**KIRKLEES METROPOLITAN COUNCIL
INVESTMENT & REGENERATION SERVICE**

DELEGATED DECISION TO DETERMINE PLANNING APPLICATIONS

Reference No:	2024/62/91900/E
Site Address:	1, Hyrst Garth, Batley, WF17 7AD
Description:	Erection of single storey side and rear extensions and loft conversion with rear dormer
Recommending Officer:	Morgan Braithwaite

OFFICER REPORT

A 24'9 1/4" SIDE EXTENSION WIDTH REDUCED TO 6'2" W
PR LOFT PLAN HGB / 103^A

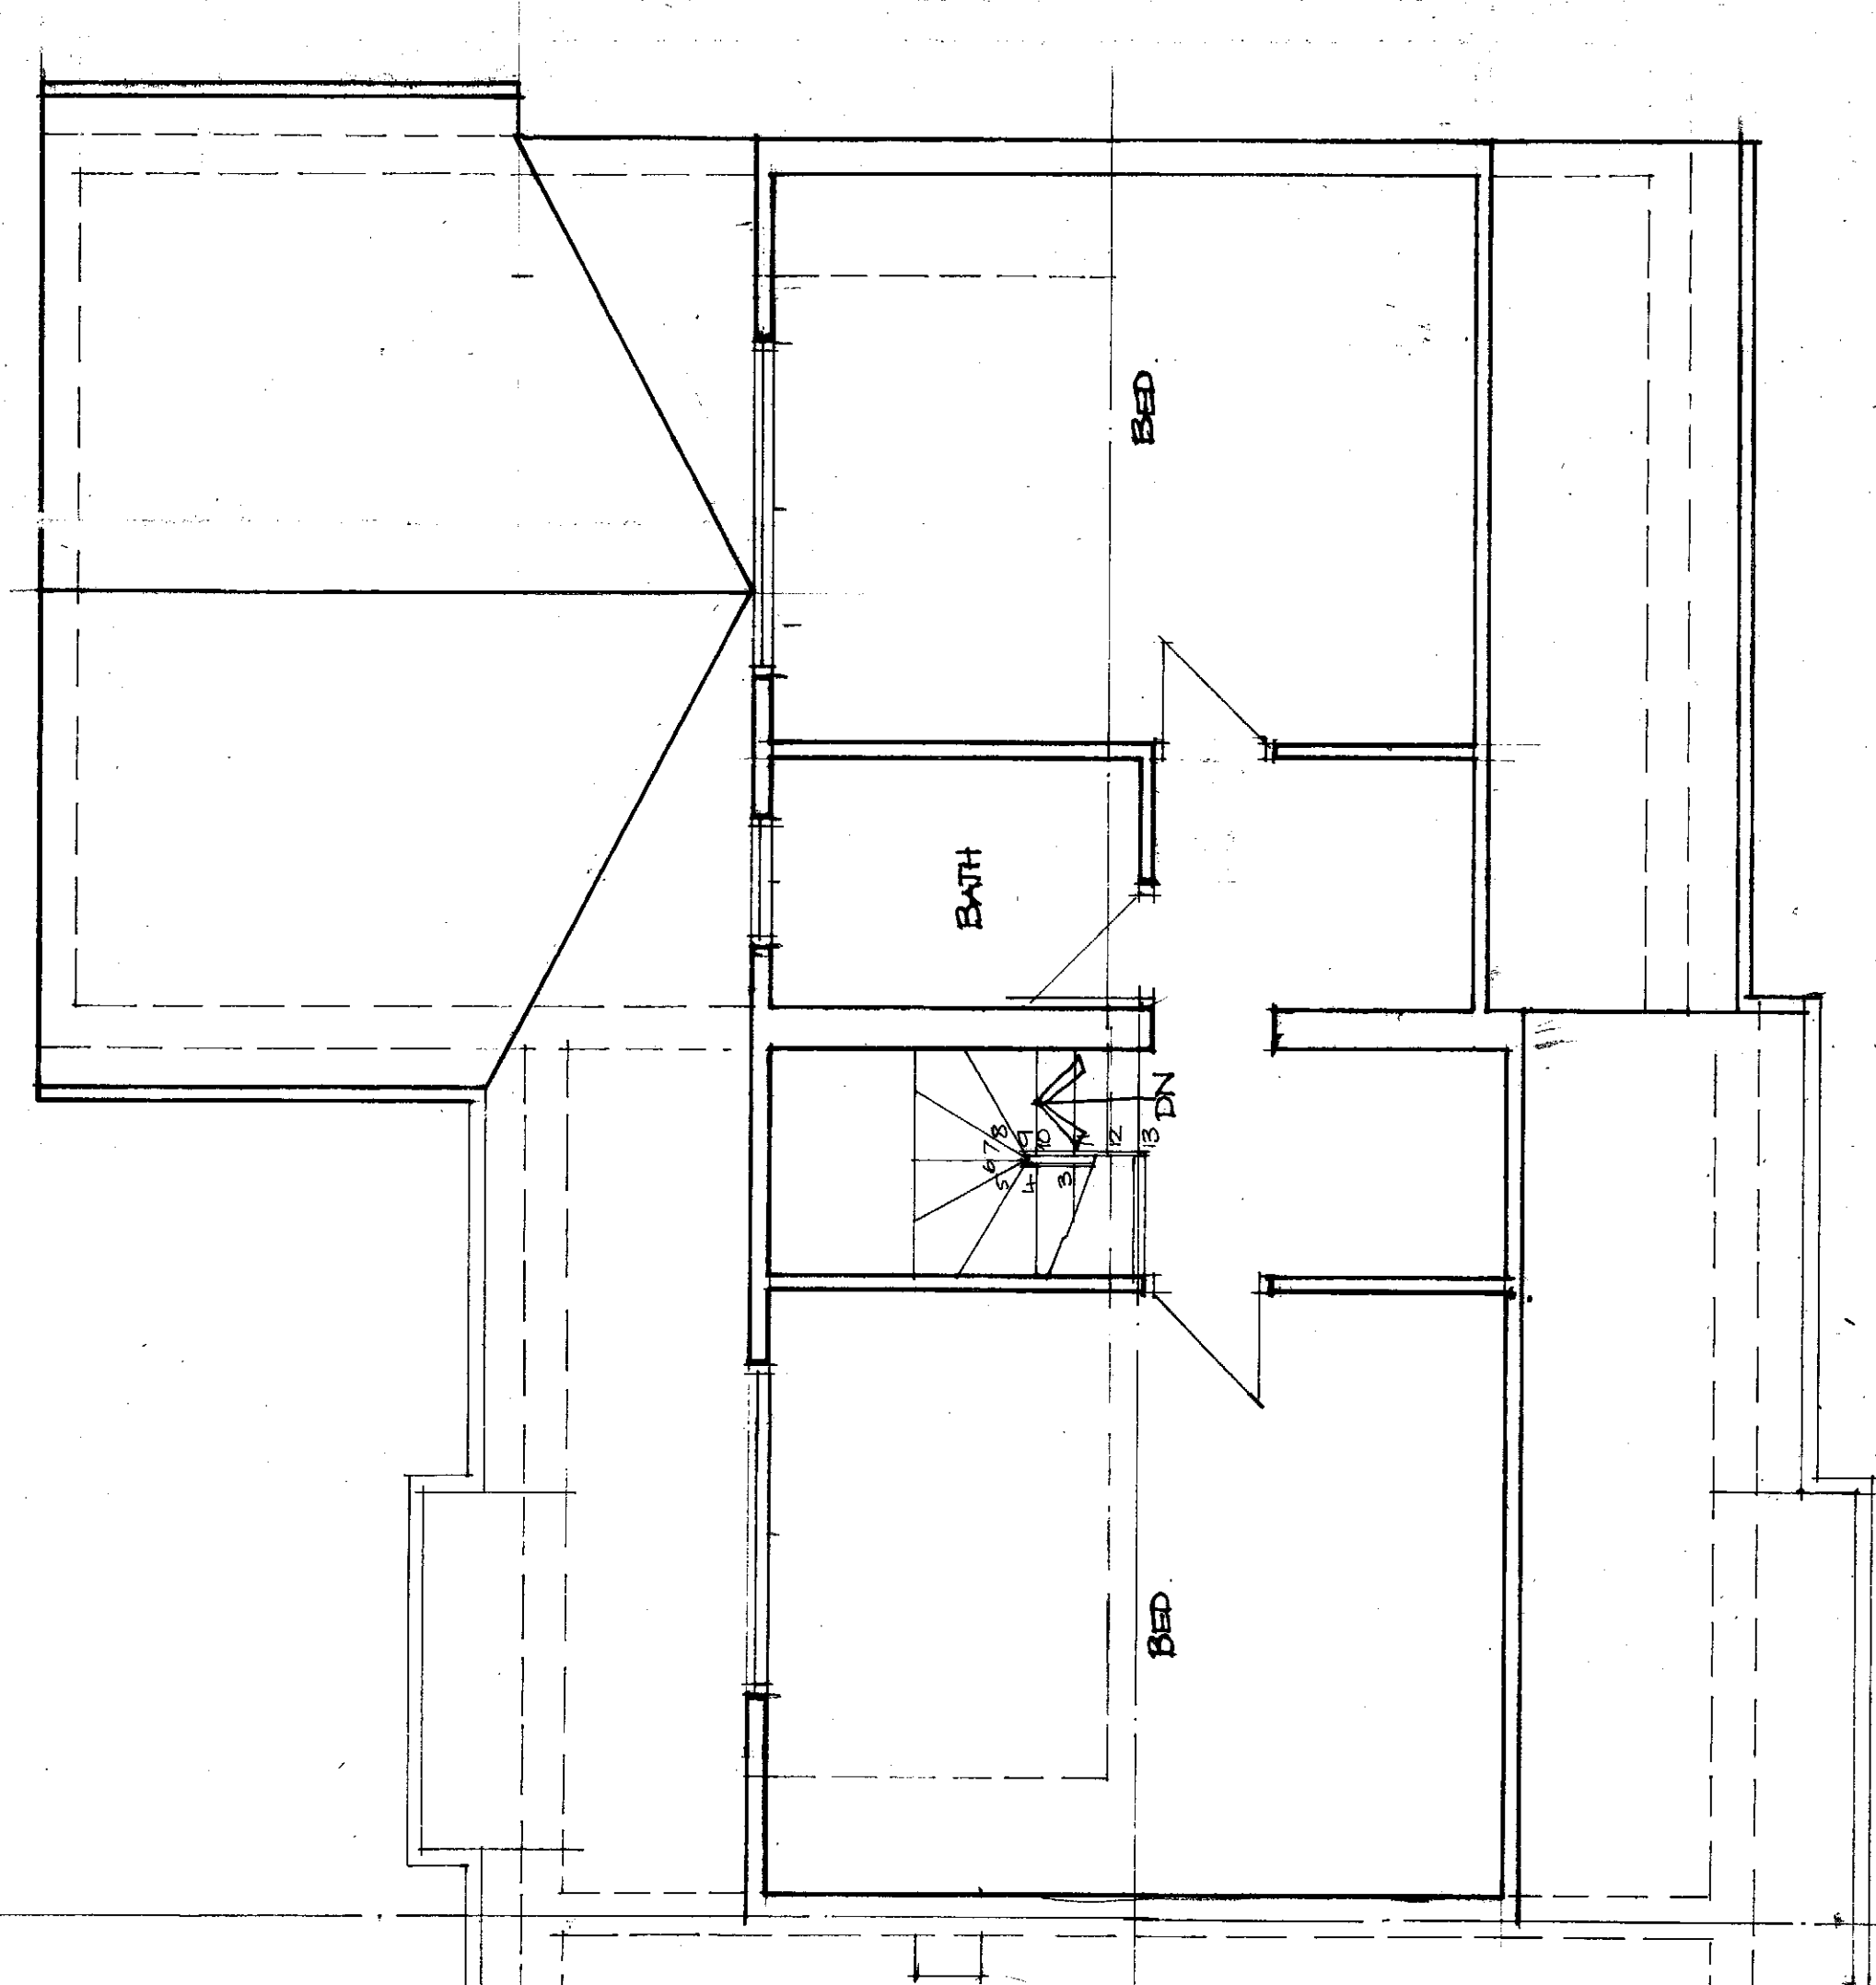
The agent was contacted and it was requested that the width of the proposal was reduced. This was due to the potential for the proposed works to appear as an additional dwelling rather than a subservient addition to an existing dwelling.

Alterations to the submitted plans were sought in order to see a reduction in the width of the proposal. This was due to concerns over the visual impact of the side extension. Amended plans have been submitted showing a 1m reduction in the width of the side extension. These plans have been deemed acceptable.

Amended plans have been submitted seeing a reduction in the width of the proposal by 1m. This amendment has been deemed acceptable, on balance.
